1 December 2021

Our Reference: SYD16/00625/17  
DPIE Reference: SSD-9978934

**SSD-9978934: EXHIBITION OF ENVIRONMENTAL IMPACT STATEMENT (EIS)  
STAGE 2 COCKLE BAY WHARF MIXED USE DEVELOPMENT  
249 WHEAT ROAD, COCKLE BAY**

REV	DESCRIPTION	DATE	DRAWN	INITIAL	DATE
A	ISSUE	08/09/21	NT		
	DESCRIPTION: PRELIMINARY PLAN

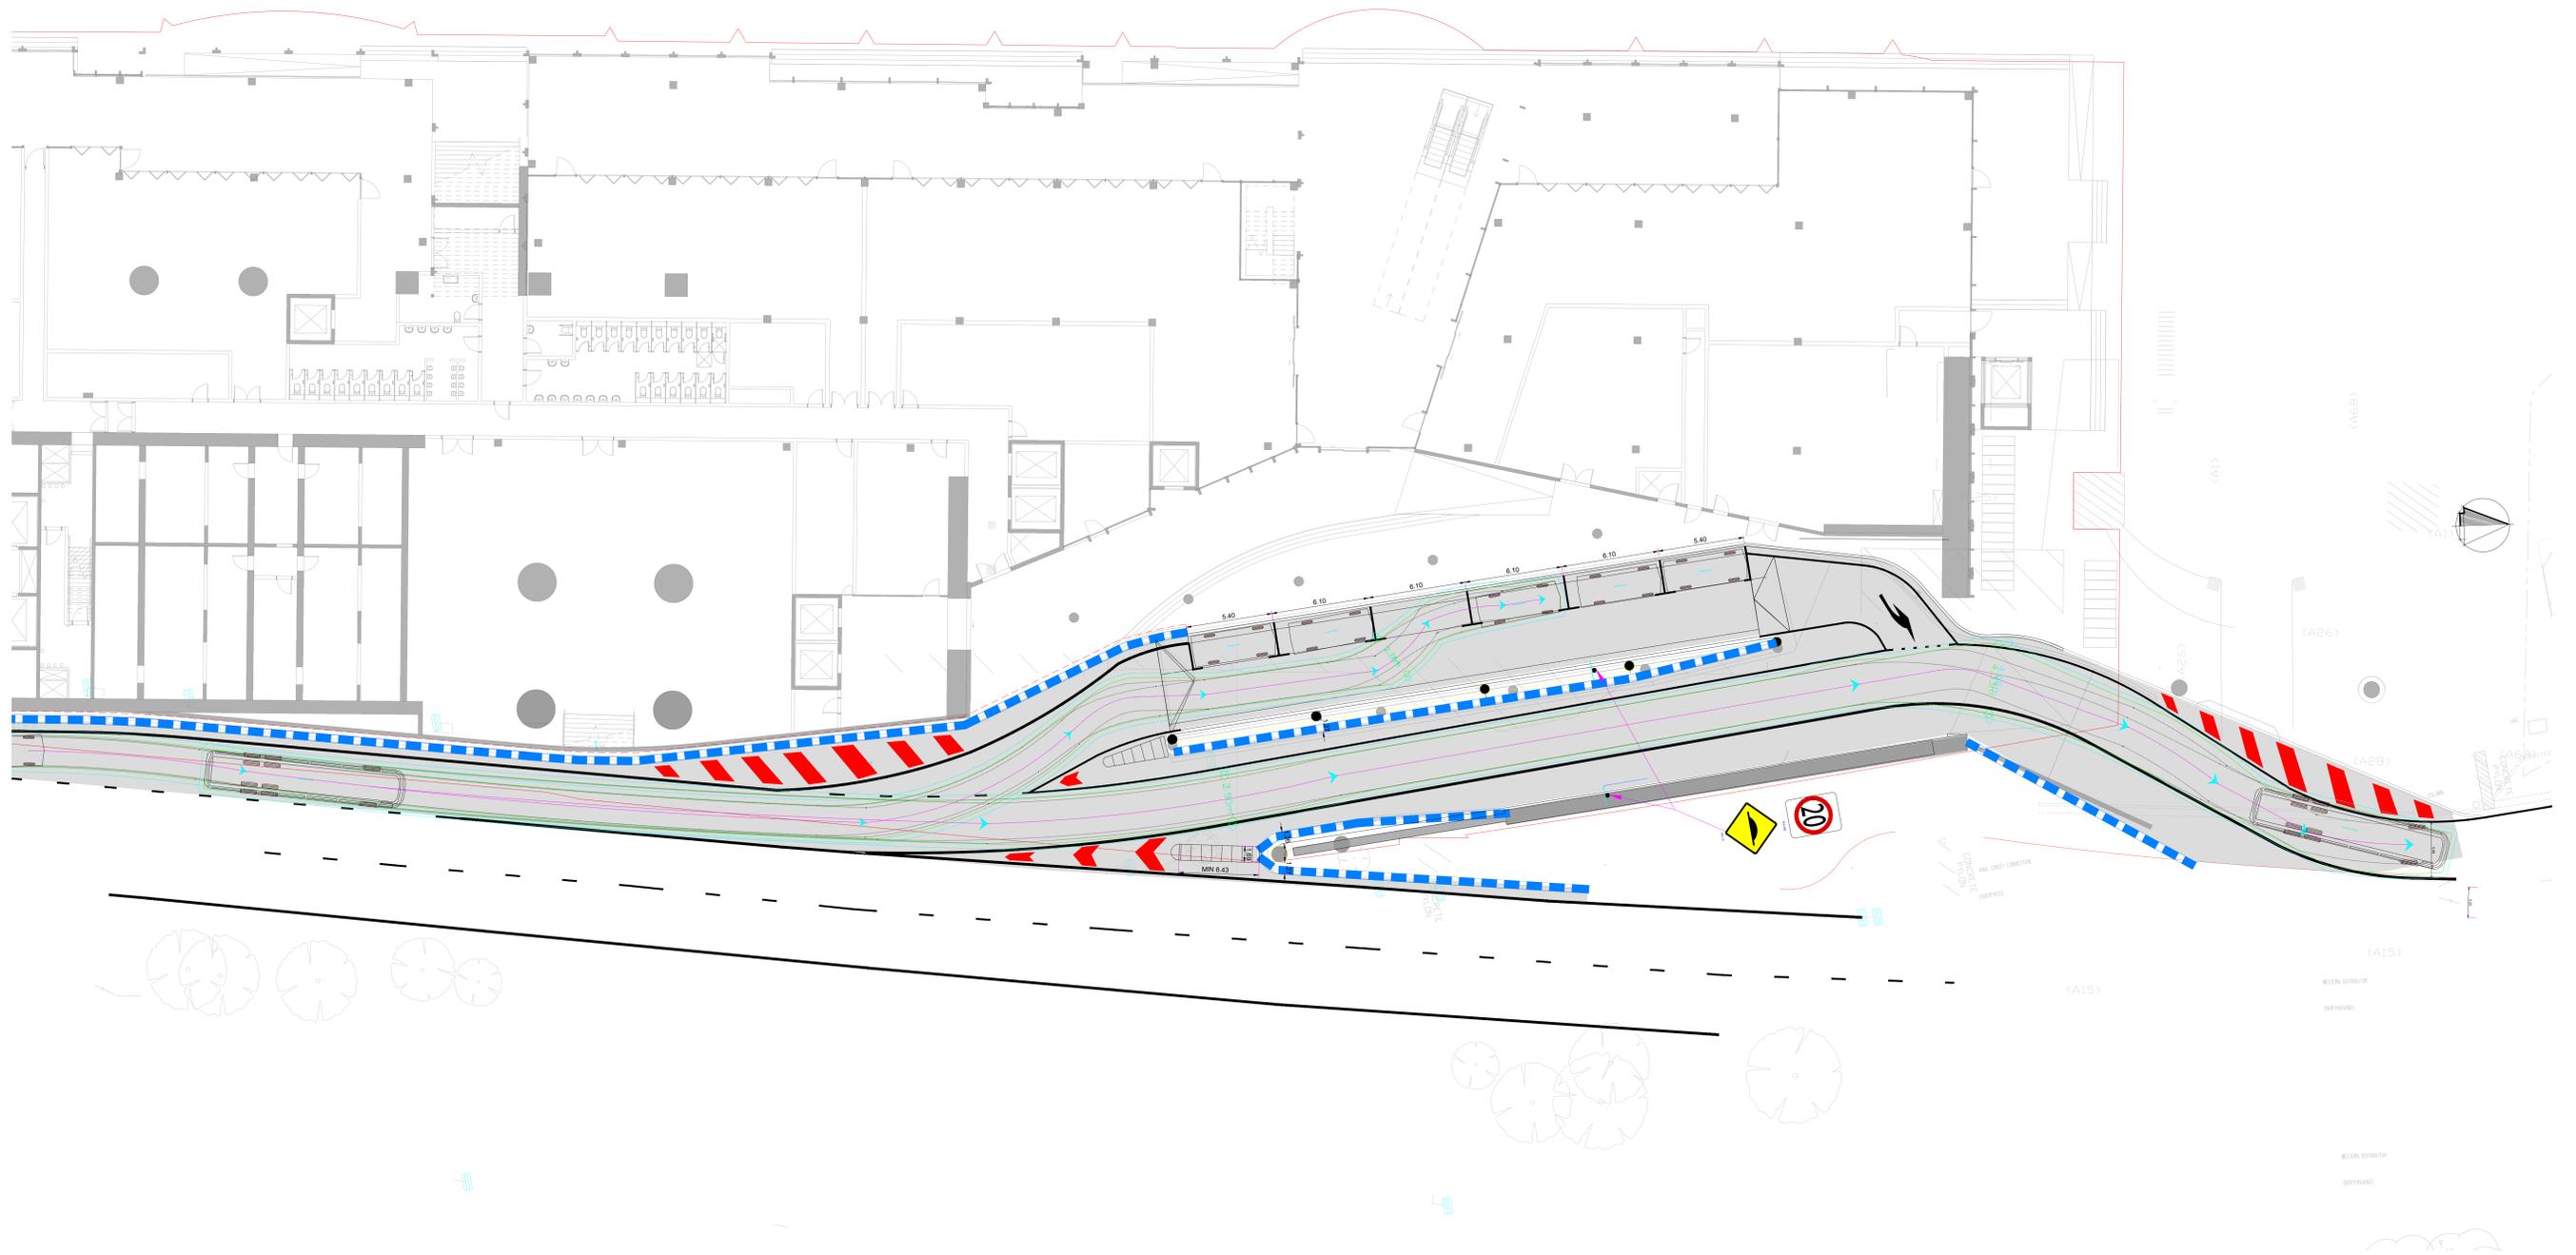
- Further it is not clear if the vehicle drop off, including ingress and egress, has been designed to accommodate stretched limousines which may serve the proposed development and the maximum coach size that the proposed Wheat Road configuration has been designed to as this is not clear from the swept path analysis provided in the Traffic Impact Assessment. It is also noted that the swept path analysis identifies that the coach design vehicle encroaches into the land outside of the proposed extent of the Wheat Road roadway.

- Details of the largest vehicle size that the proposed vehicle drop off, including ingress and egress and Wheat Road configuration have been designed should be provided (including swept paths and vehicle clearance heights), taking into consideration the use of coaches and stretched limousines within the vehicle drop off and Wheat Road configuration. Further, provision of a swept path analysis identifying that the proposed Wheat Road configuration adequately accommodates the coach design vehicle should also be provided.
